CITY OF ALBUQUERQUE

May 7, 2018

**Re: Primrose School
Erosion and Sediment Control Plan
Engineer's Stamp Date 5-4-18 (C13E029)**

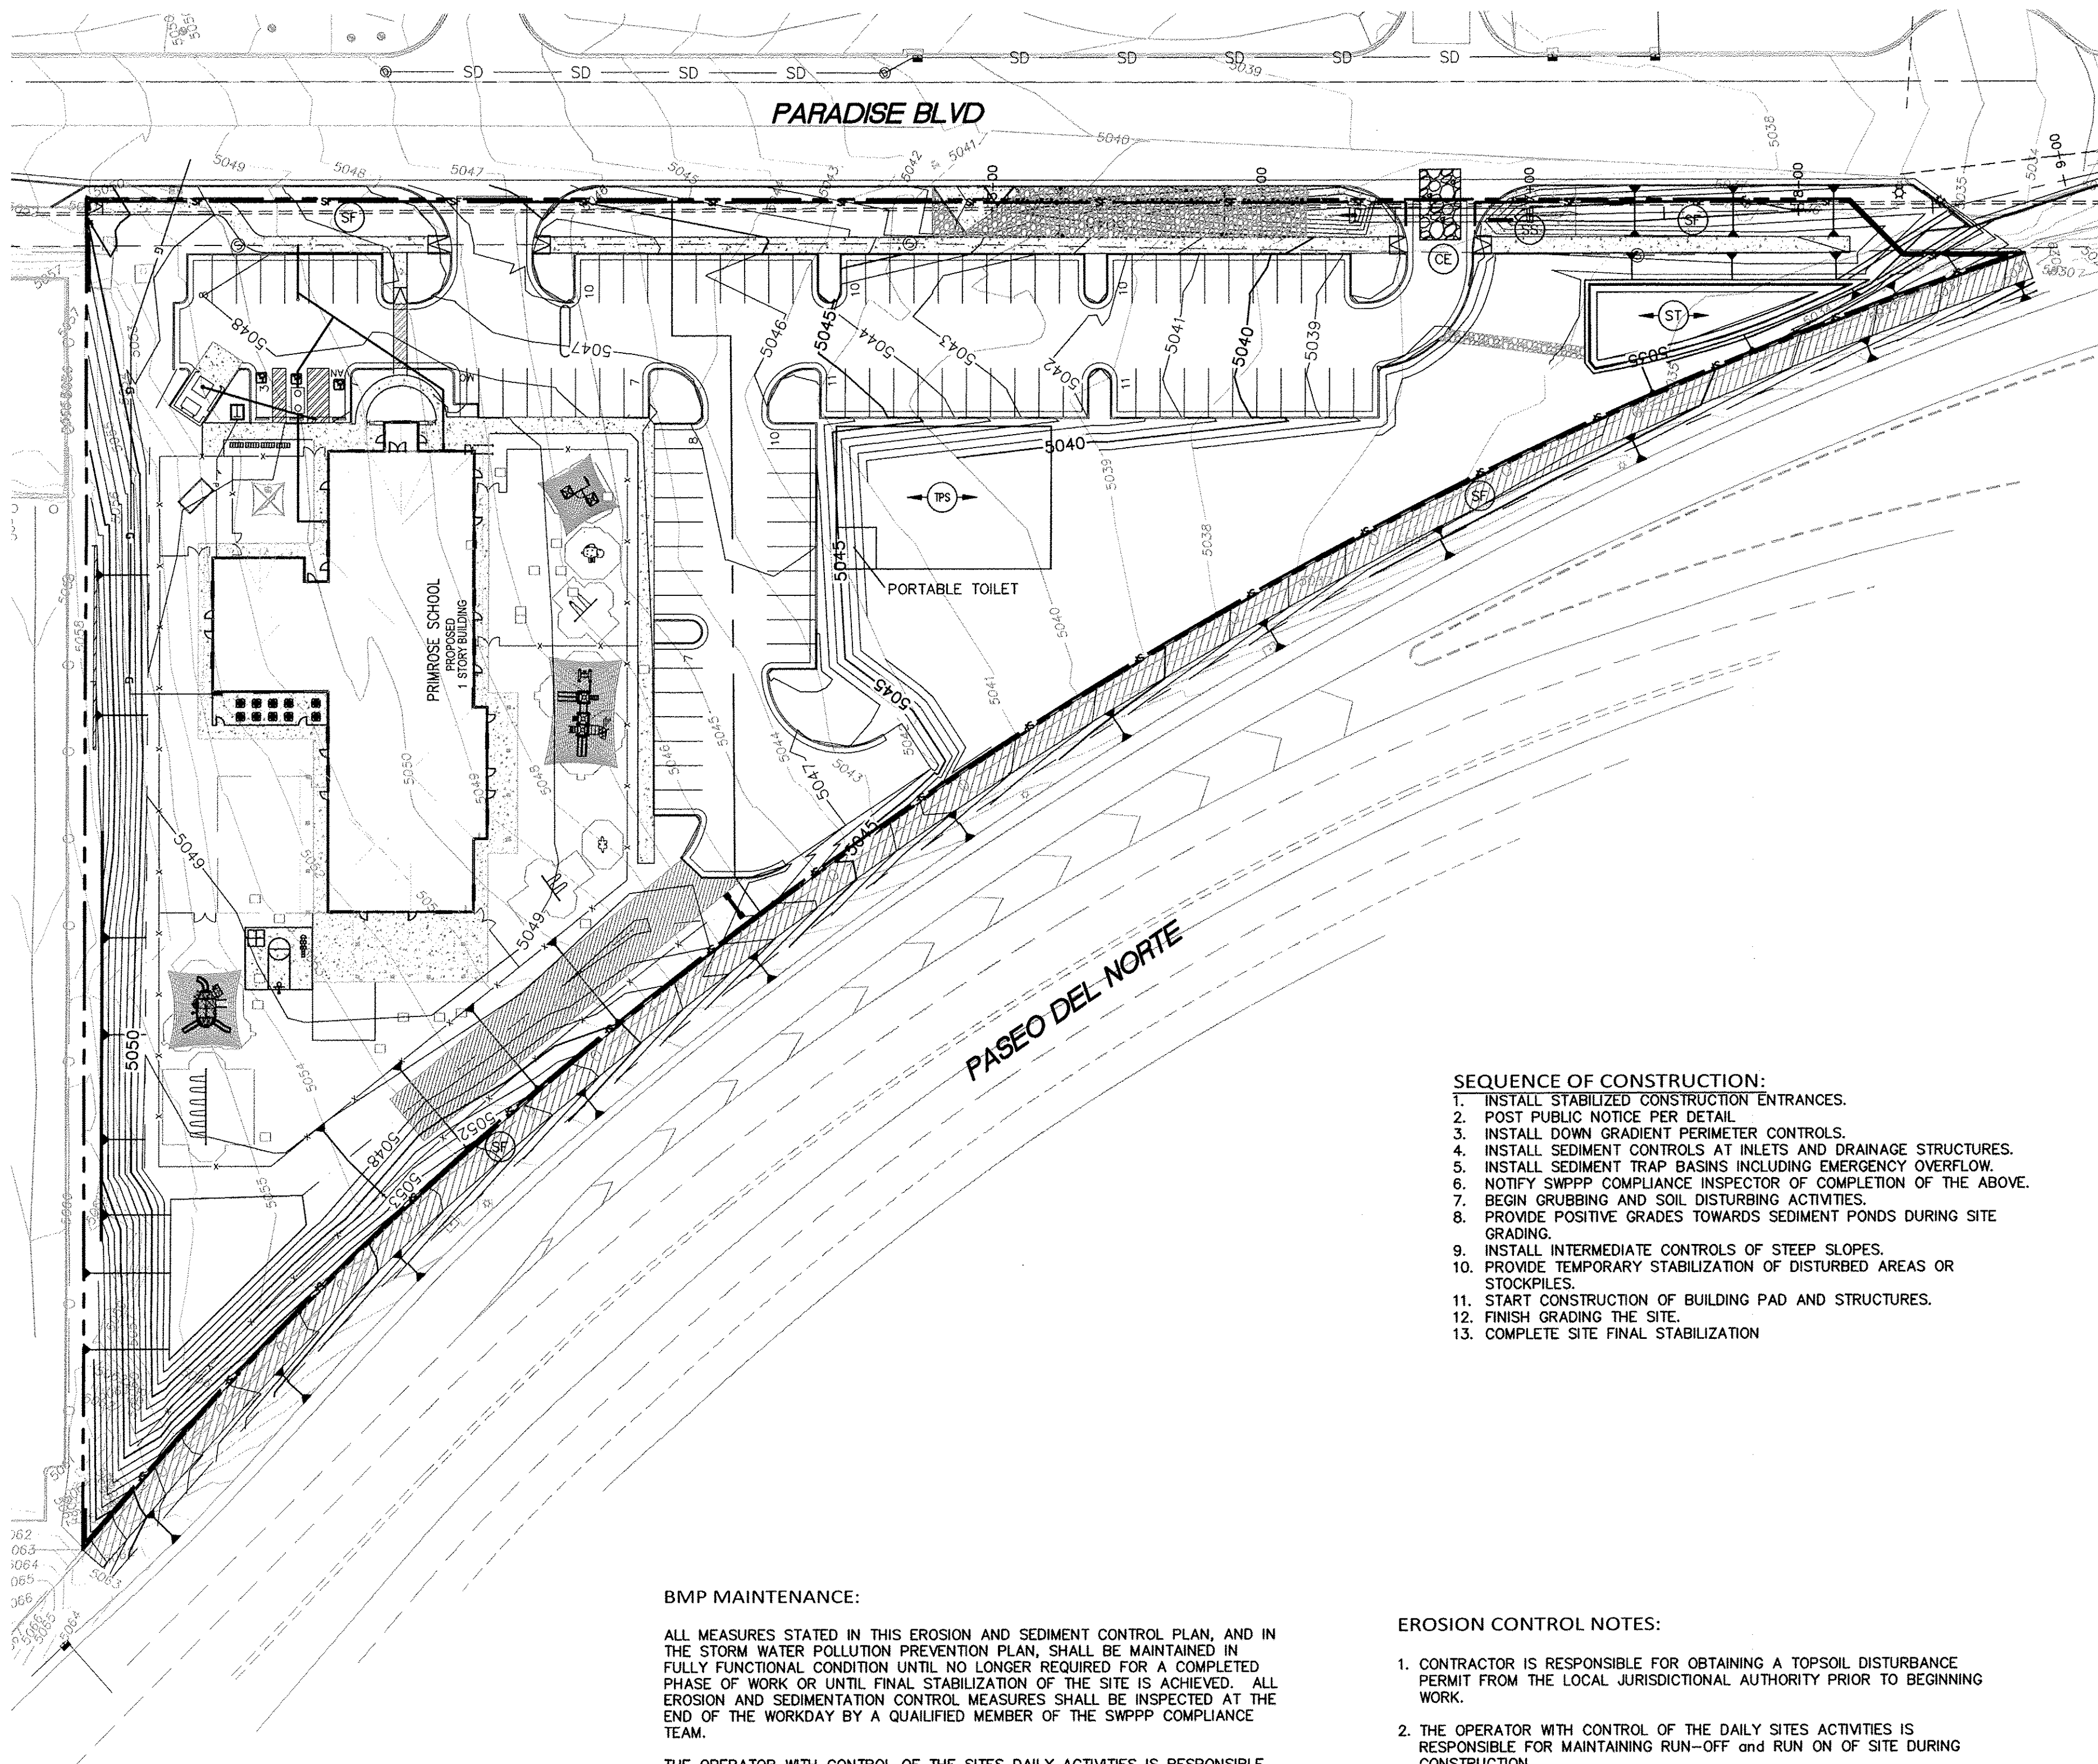
1. The proposed slope on the western edge of the site in the southwest corner is a little flatter than 2:1 ($(59-47)/27=2.25$) and is 12 feet high. It most likely will not erode, however, if the City observes significant erosion, the City will request the issue be addressed.
2. This approval is only for the work on private property and does not include approval for BMPs for construction or for grading in the NMDOT ROW.
